Application for a Non-Material Amendment Following a Grant of Planning Permission

Construction of single storey rear extension, first floor side extension including increase in ridge height with front/rear dormers; loft conversion and extension including rear rooflights; patio extension and juliet balcony; internal alterations and alterations to fenestration; construction of detached double garage; replacement of existing tennis court with lawn.

23/1627/FUL

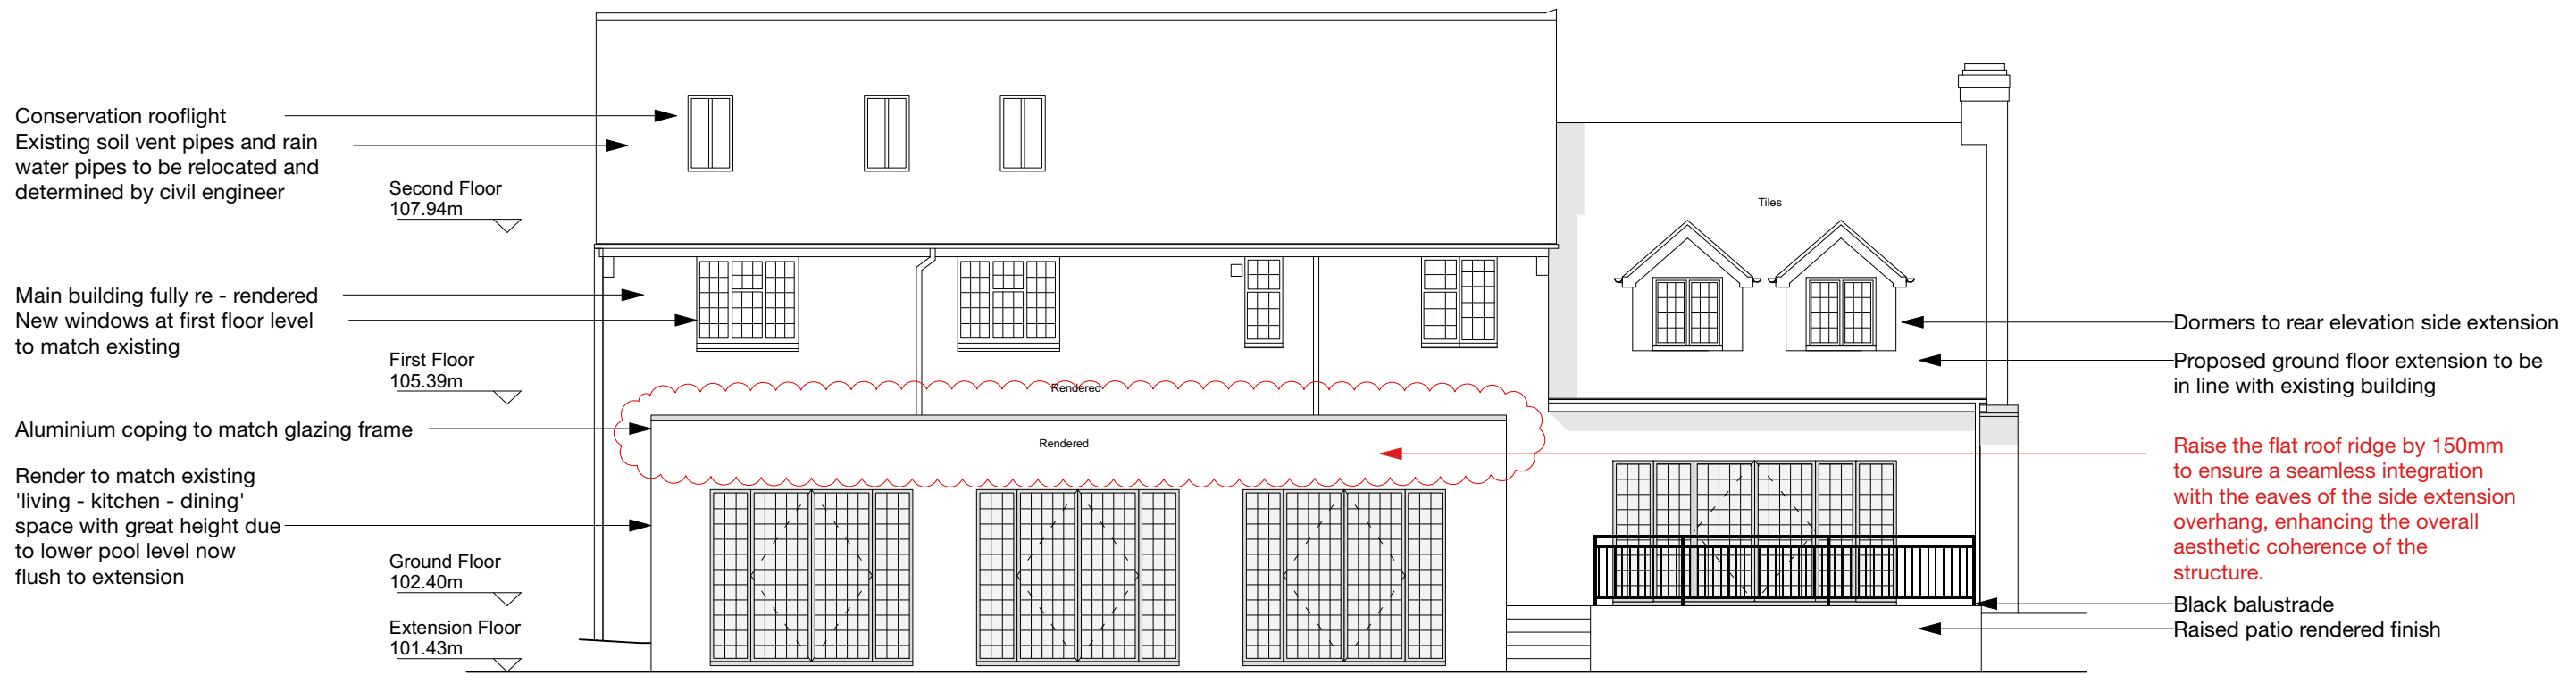
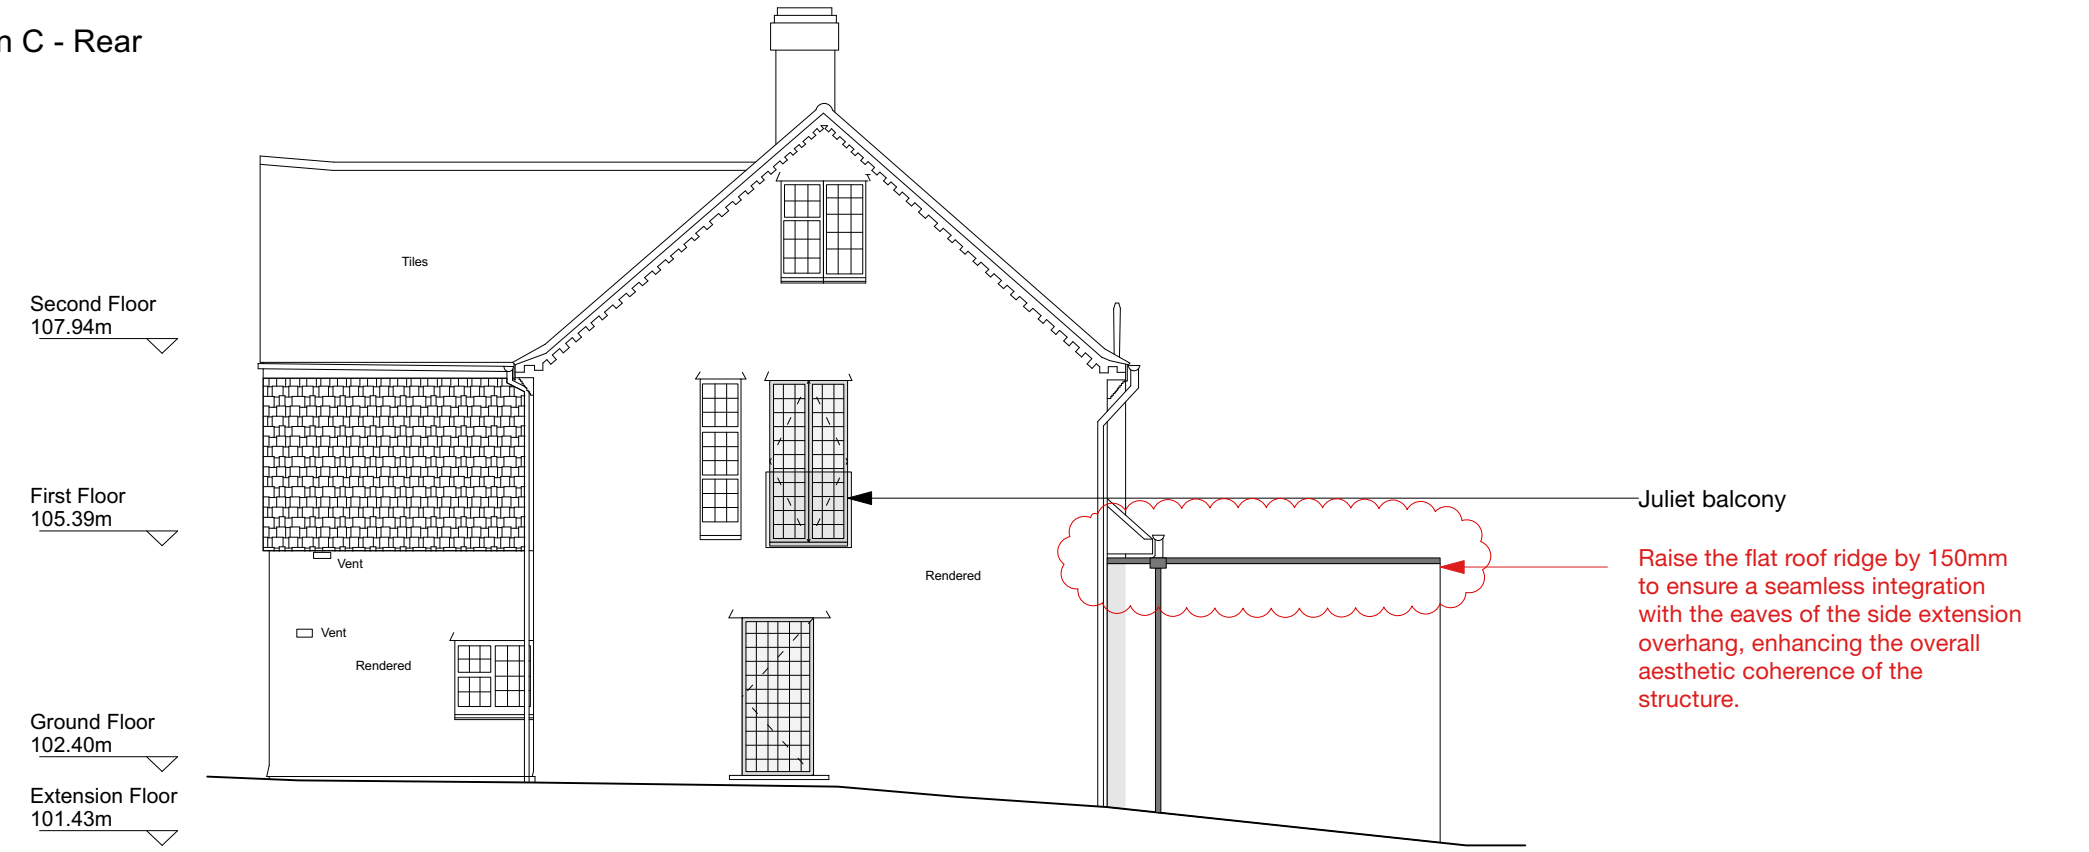
Raise the flat roof ridge by 150mm to ensure a seamless integration with the eaves of the side extension overhang, enhancing the overall aesthetic coherence of the structure. Internally, the increase in height will allow the height of aperture above the glass balustrade in the hallway (looking into the new extension) to be the height of a standard door

There are concerns of large steel works required, which would lower the headroom when the user stands adjacent to the balustrade within the existing building. Therefore an increase of 150mm will allow sufficient headroom and space for services and steels.

2134_401 and 2134_402
Revision B
